BCA ASSESSMENT REPORT

*372-374 Mann Street & 35-37 Dwyer Street, North
Gosford NSW*

Project Number: 118363

Revision: 4.0

1 LOWER GROUND FLOOR PLAN
SCALE 1 : 250

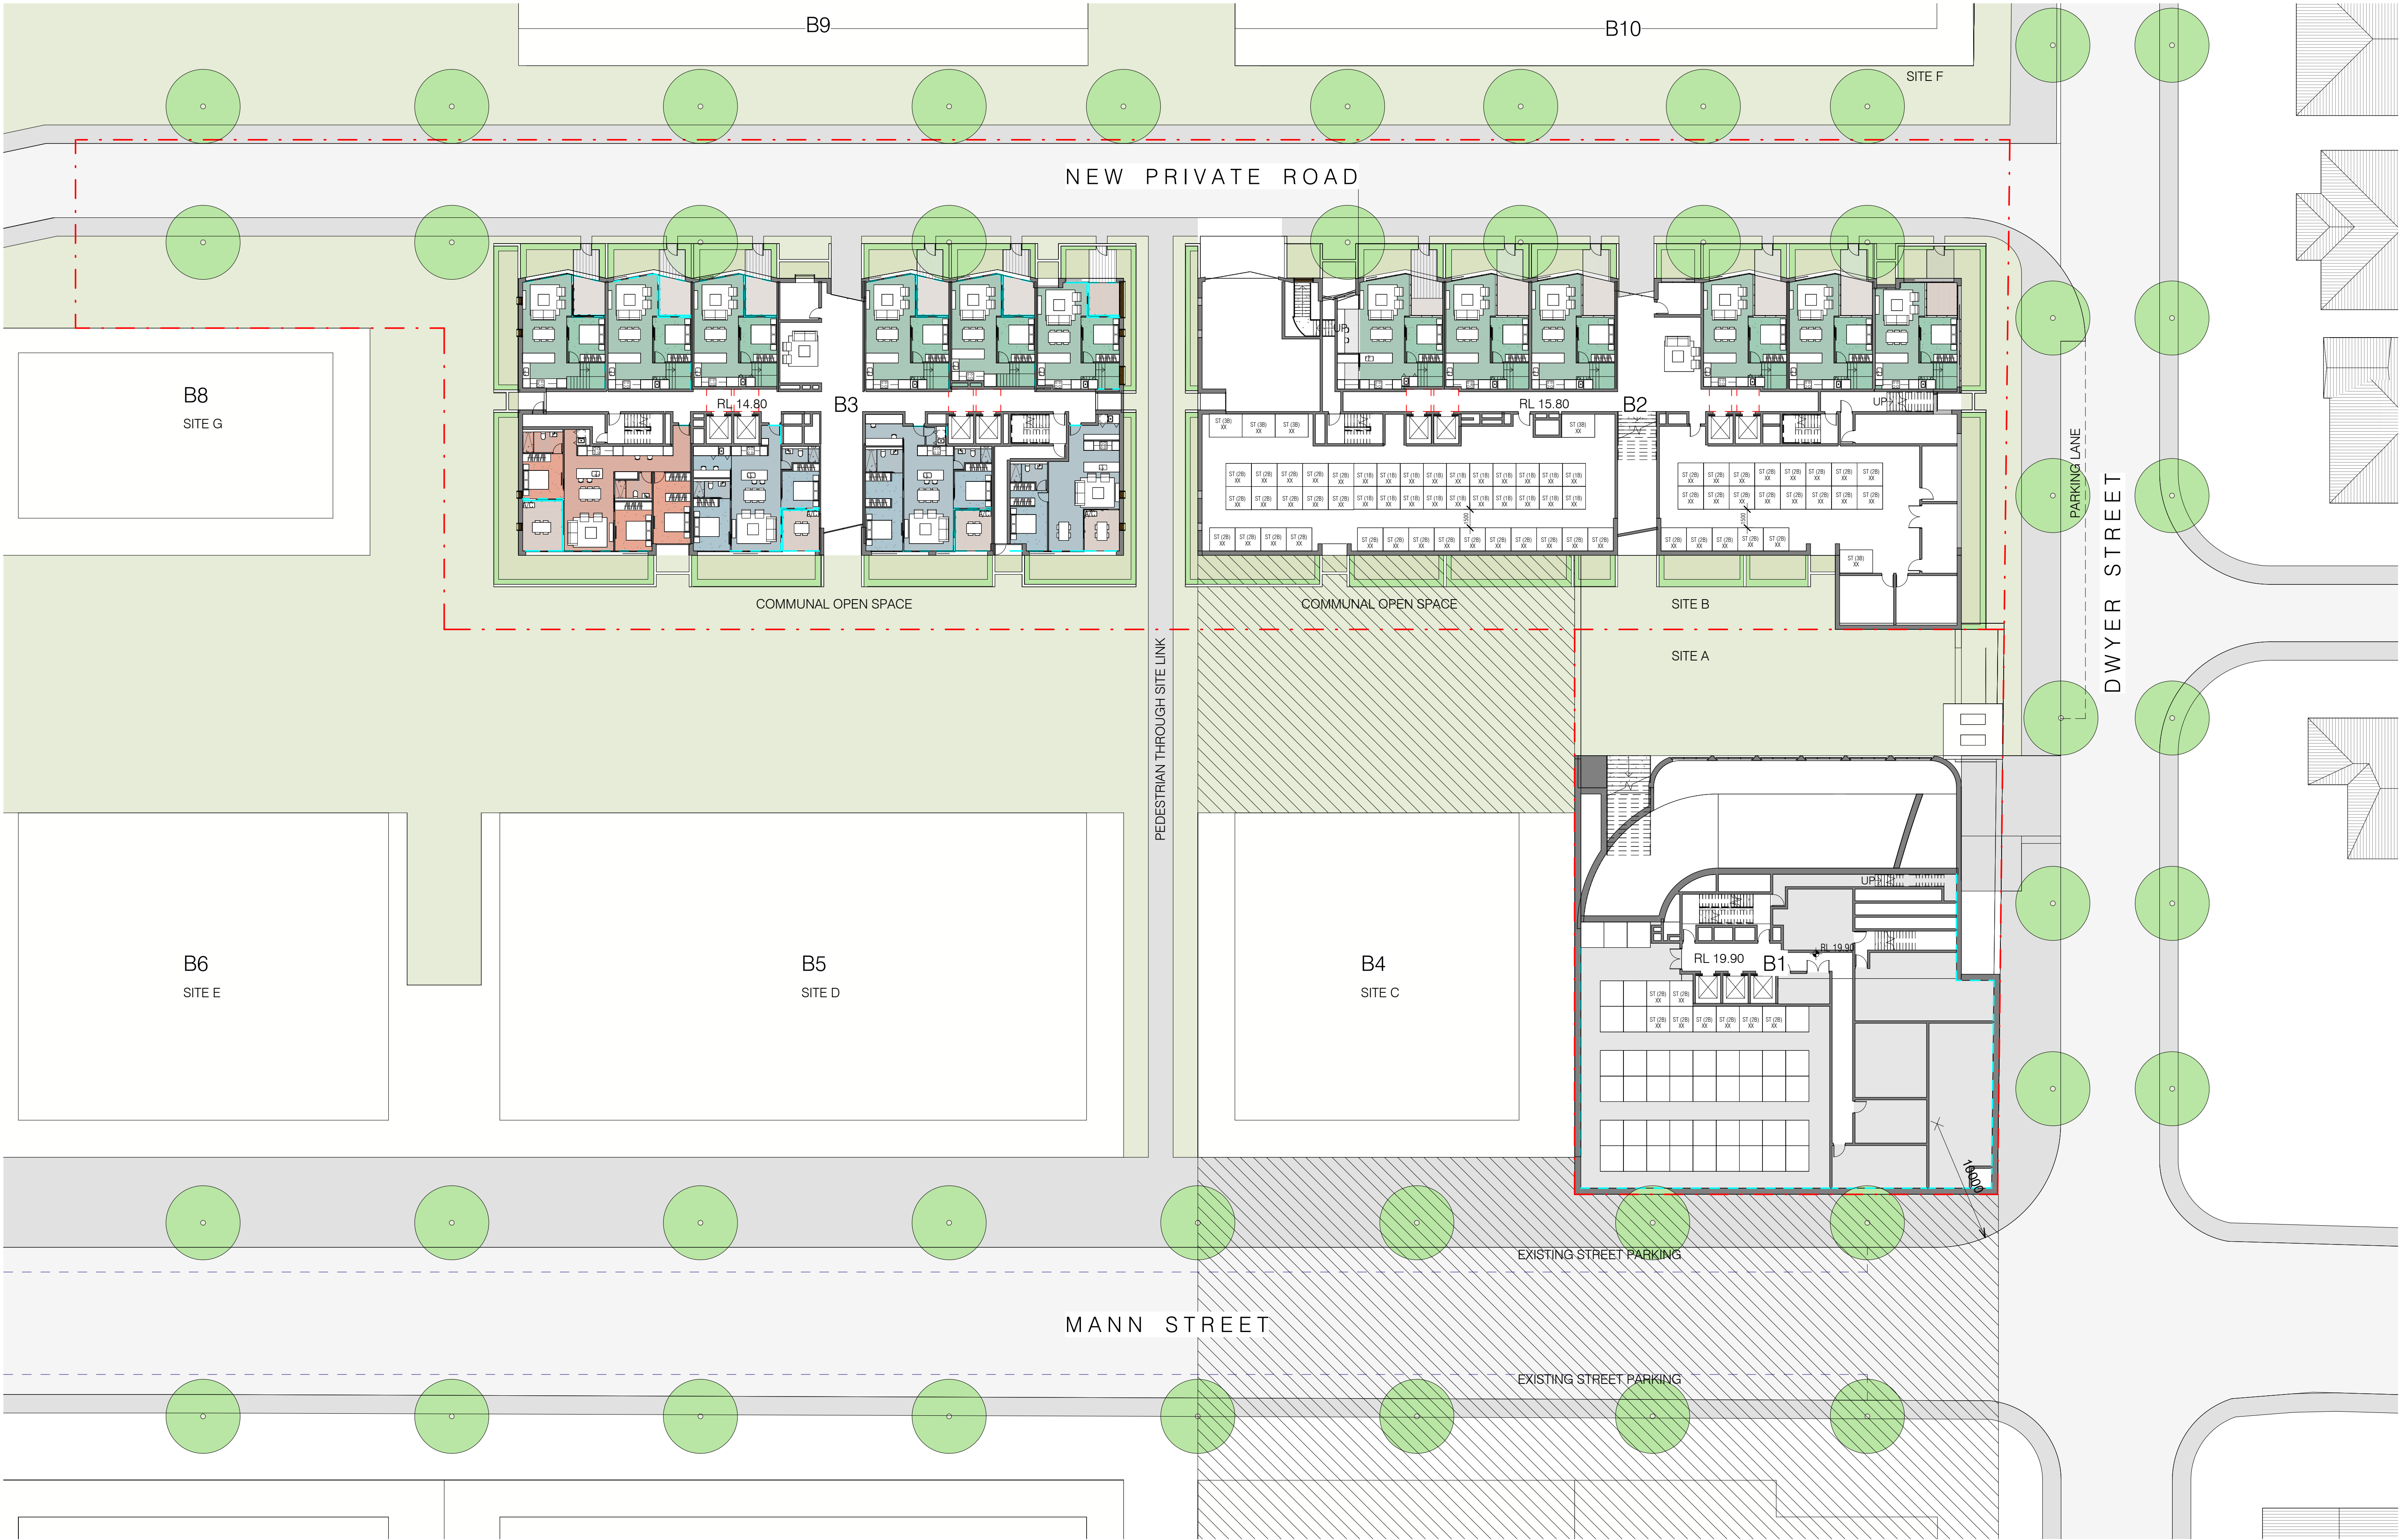
Item	Description	BCA Provision
	43 m to an exit lieu of 40 m.  The diagram shows the layout of Basement 1 with various rooms and circulation paths. A red dashed line indicates a travel path from a starting point (marked with a green square) to a Point of Concern (POC, marked with a red dot). The distance along this path is 41.96 m. A green dashed line indicates an alternative path, with a distance of 42.74 m. Other rooms labeled include RETAIL, KITCHEN, B1, and RETAIL WORKSHOPS. A note specifies: '32 CAR SPACES (30% RETAIL, 1% RETAIL ACCESSIBLE, 12 VISITOR) HL: 9.90'. <i>Basement 1 Travel Distances</i> - Lower Ground – 29 m to a POC in lieu of 20 m.  The diagram shows the layout of the Lower Ground level, primarily consisting of a large parking area with individual car spaces marked. A red dashed line indicates a travel path from a starting point (marked with a green square) to a Point of Concern (POC, marked with a red dot). The distance along this path is 28.13 m. Other areas labeled include 'POLYMERIZATION SERVICES' and 'CAPTIONED BY OWNER'. <i>Lower Ground</i> - Level 1 – 7 m to a POC in lieu of 6 m.

13.	<u>Site A (Building 1)</u> It is recommended that a Fire Safety Engineer provides early input to determine whether the location of the Fire Control Room (fire control centre) can be addressed as part of a performance solution.  <i>Lower Ground Fire Control Room location</i>	S19C4 Location of fire control centre S19C9: Doors to a fire control room
Non-fire-related Performance Solutions required

1 UPPER GROUND FLOOR PLAN
SCALE 1 : 250

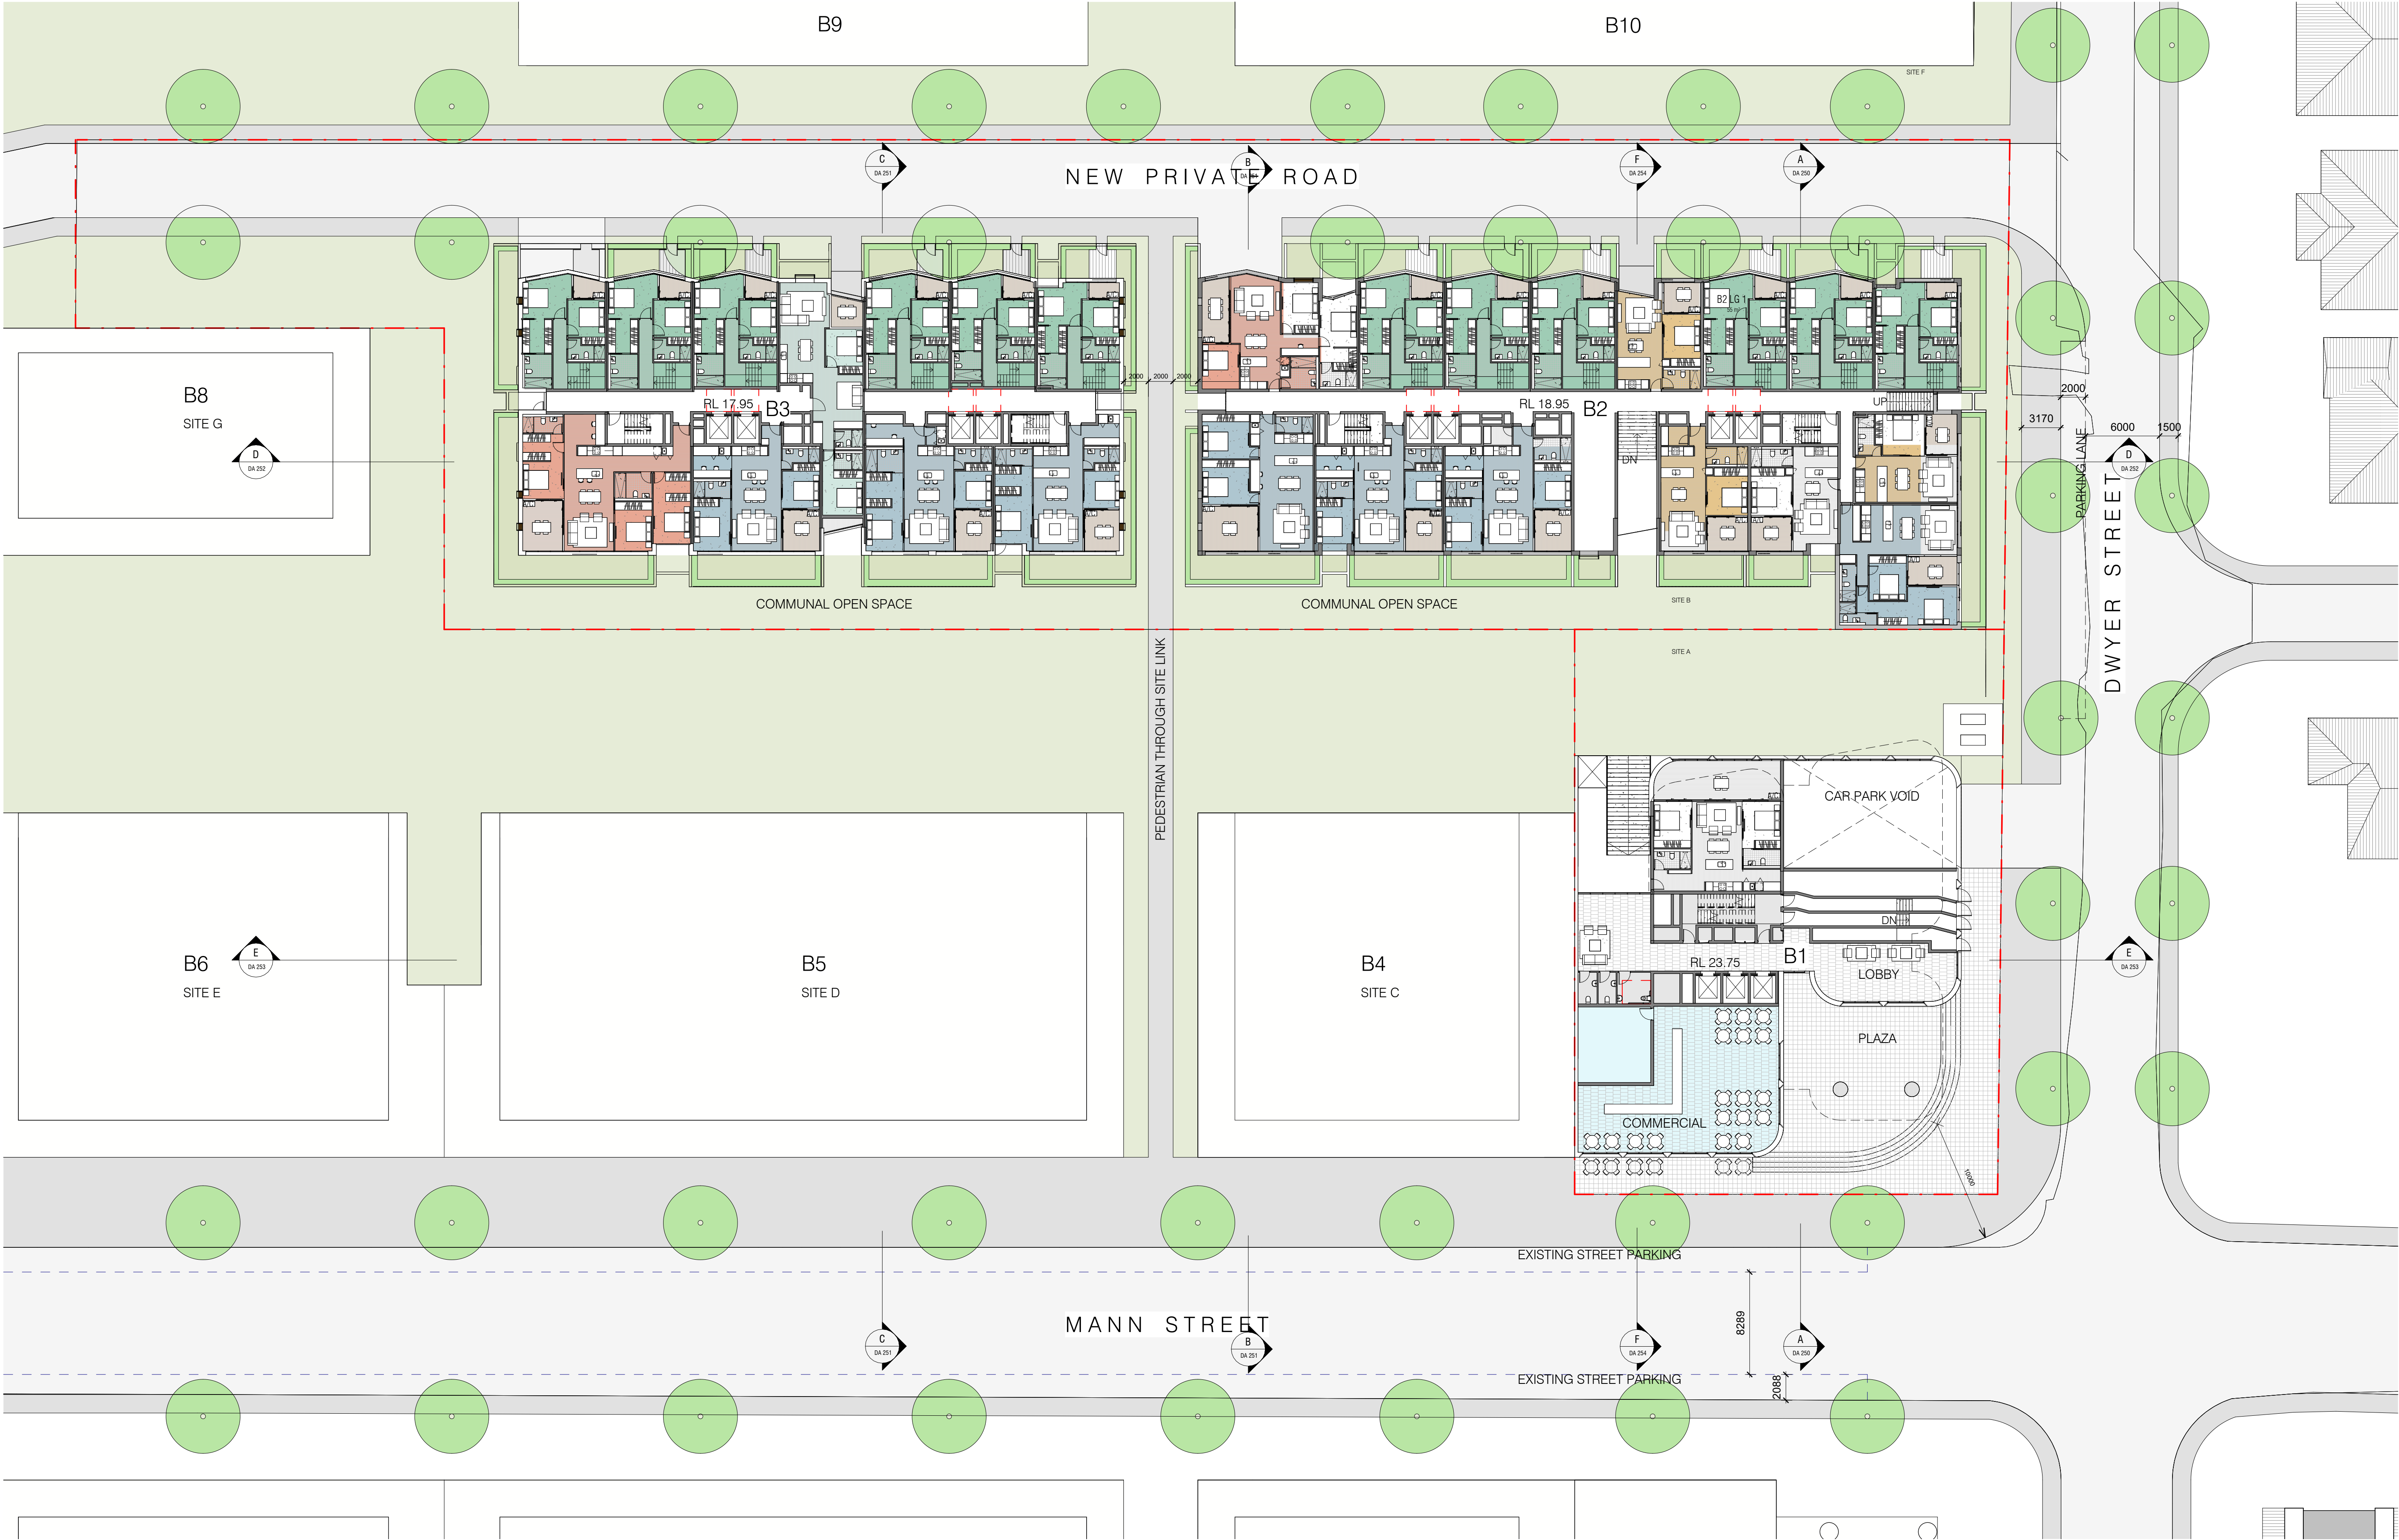
14.	<u>Site A – Building 1 Upper Ground Level – Class 6 Tenancy</u> Sanitary facilities serving the Site A Building 1 Upper Ground Level Class 6 Tenancy are to be gender designated, excluding the accessible unisex sanitary facility. Jensen Hughes can prepare a Performance Solution that permits the Unisex WCs. Alternatively, the architectural plans are to be updated to assign a gender to these sanitary facilities. 	NSW F4D4: Facilities in Class 3 to 9 buildings
